ASSESSMENT REPORT

Sydney Southwest Private Hospital MP 10_0091 MOD 2

This report is an assessment of a request to modify the Major Project Approval (MP 10_0091) for the construction of a four-storey extension to the existing Sydney Southwest Private Hospital (SSPH) at 24-40 Bigge Street, Liverpool.

DRAWING TITLE:
EAST ELEVATION

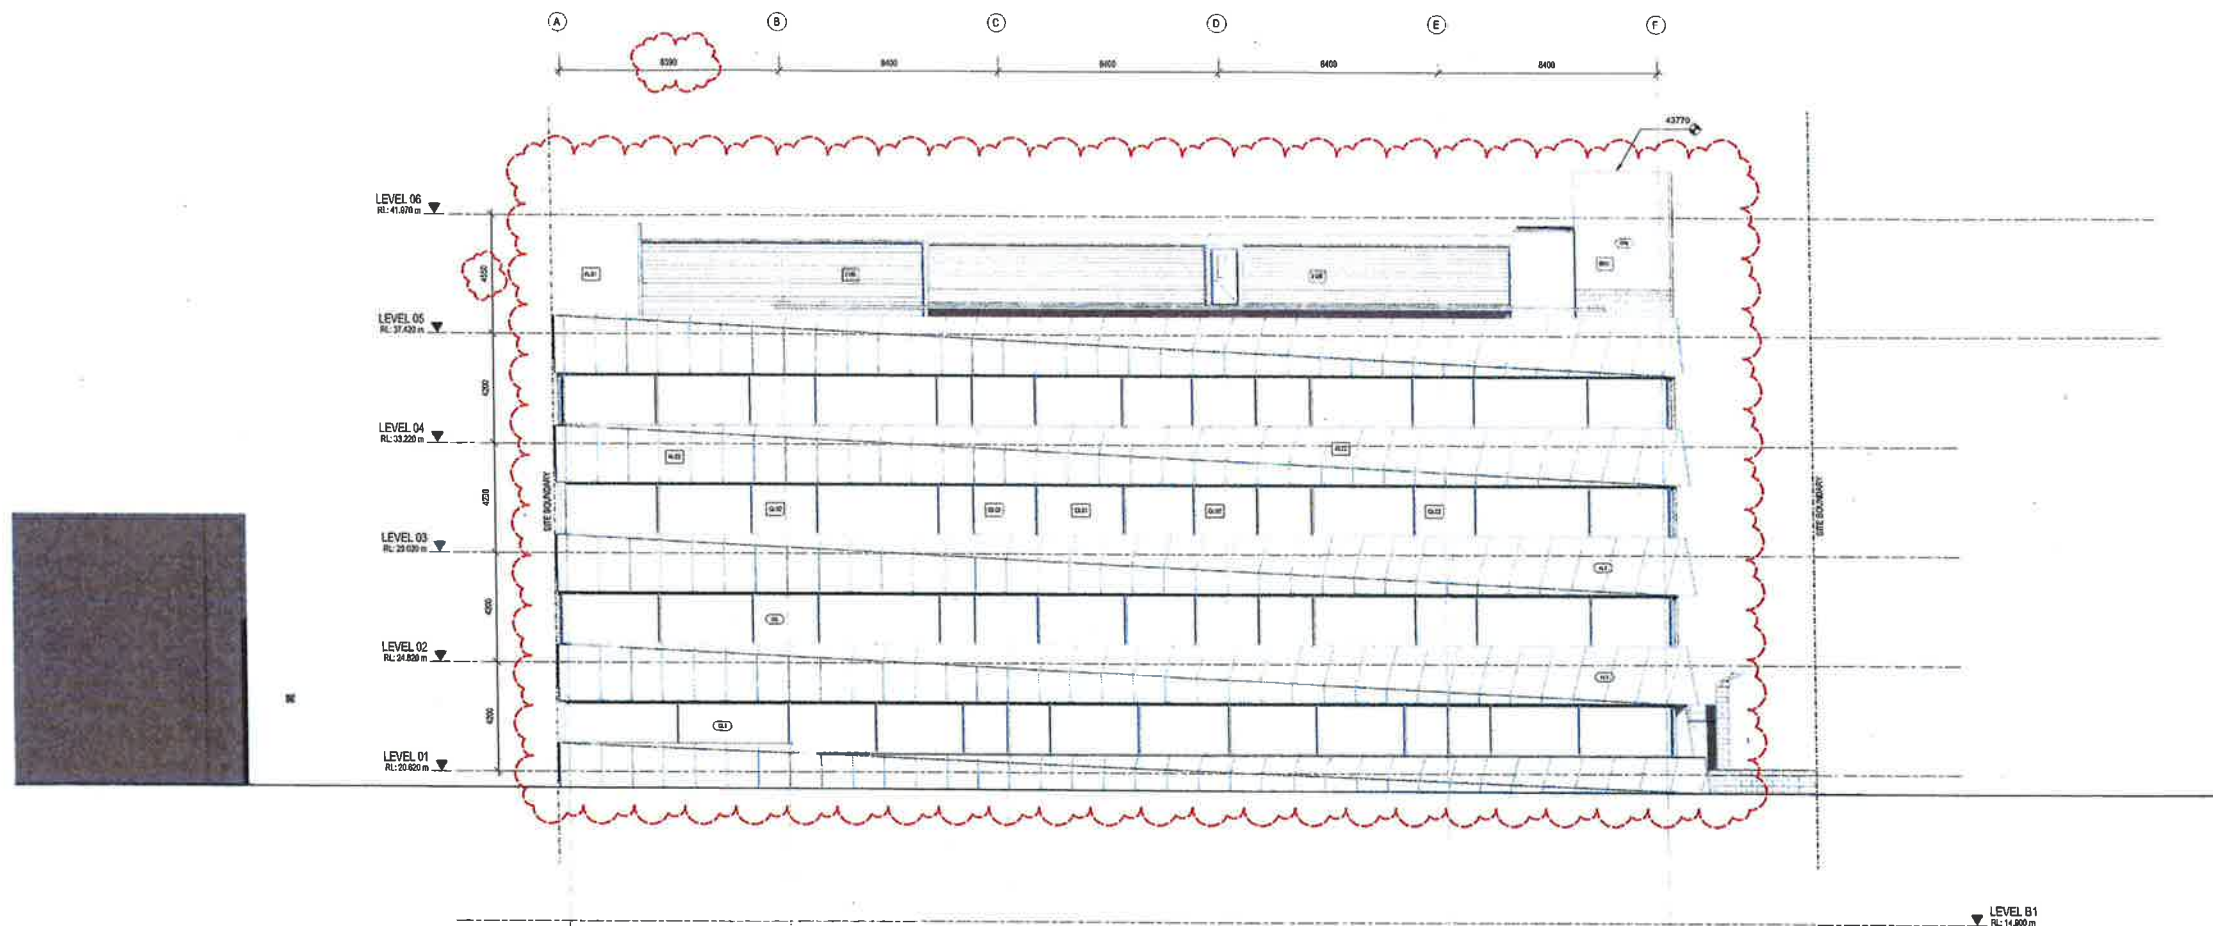
Issue	Consideration	Recommendation
<i>Built Form changes</i>	<ul style="list-style-type: none"> The proposal seeks approval to increase the height of the building by 2.35 m to accommodate a lift overrun and associated plant. This would increase the overall height of the building to 25.35 m (refer to Figure 6). The Department considers the increase in building height is acceptable as it: <ul style="list-style-type: none"> relates only to a small element of the building incorporating lift overrun and plant; is well below the 35 m height limit under Liverpool Local Environmental Plan 2008; is compatible with the built form of the surrounding area, which includes buildings up to 6-7 storeys; and would not result in any significant additional overshadowing impacts as the shadows cast from the proposal would fall predominantly on existing and approved shadows. The Department also notes the proposal seeks to increase the building setback to Bigge Street by 83 mm. The Department considers this is a minor change and it would not result in any additional visual or amenity impacts. The proposal also includes minor changes to the materials and finishes of the façade, which adopt a generally lighter colour palette. The Department is satisfied the proposed changes to the façade are acceptable and would make a positive contribution to the streetscape. Overall, the Department is satisfied the proposed changes to the built form are acceptable and would not result in any significant impacts beyond those already assessed and approved. 	No additional conditions or amendments necessary.
